January 30, 2025

**RE: Retreat at PrairieRidge Filing 3 / Traffic Generation Analysis**  
**El Paso County, Colorado** **SF2520**

**RETREAT AT PRAIRIERIDGE FILING 3**

*Traffic Generation Analysis*

RETREAT AT PRAIRIERIDGE FILING 3
Traffic Generation Analysis

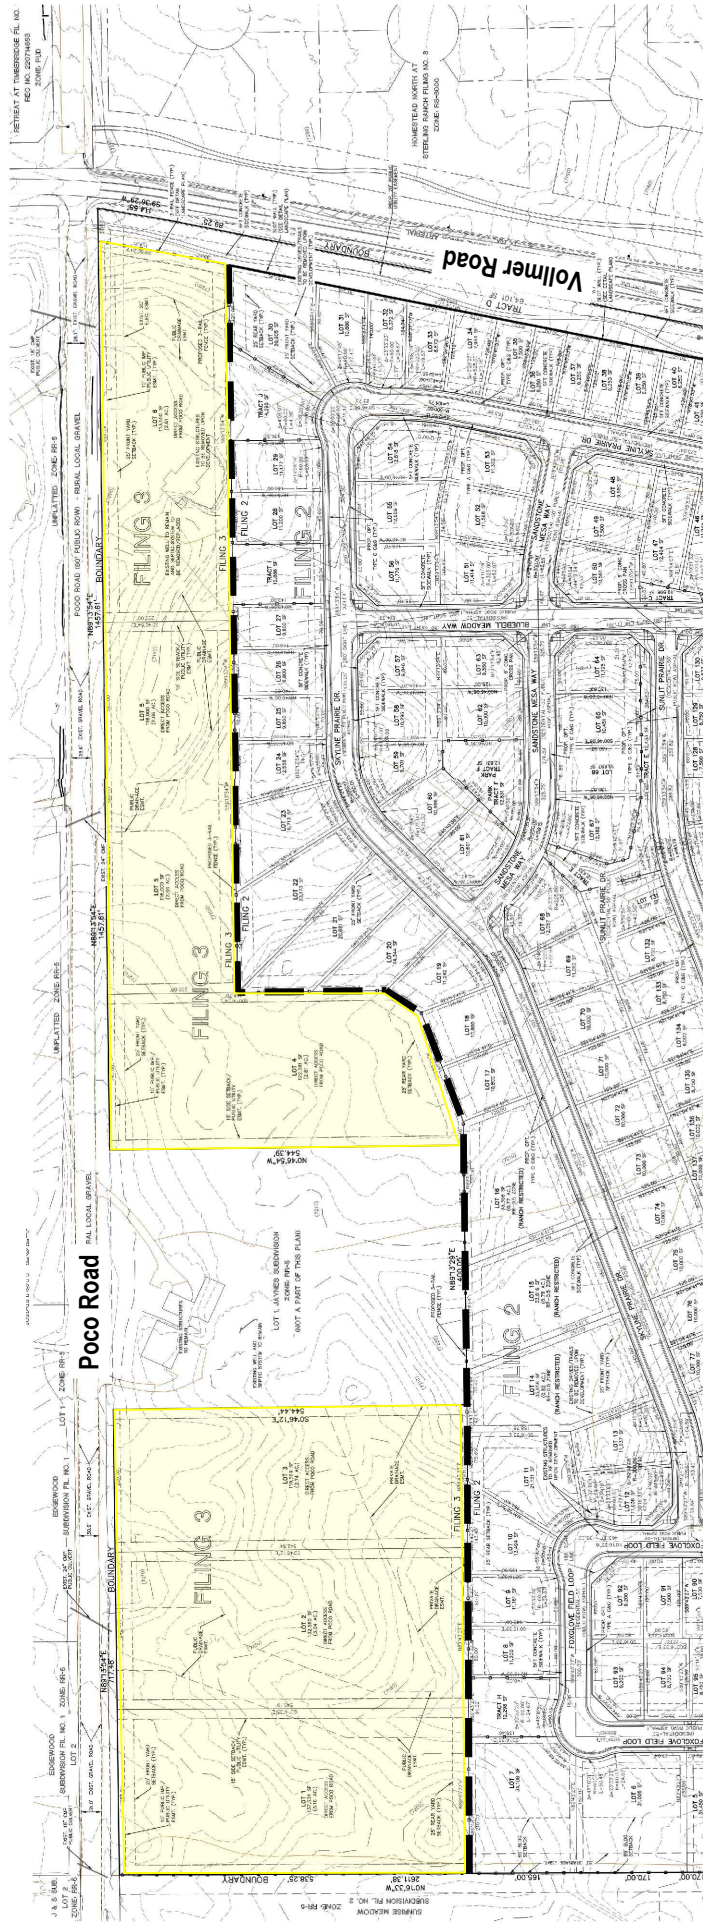
Please include existing volume on Poco Rd to determine if the road may remain gravel or if paving is required for volume above 200 trips
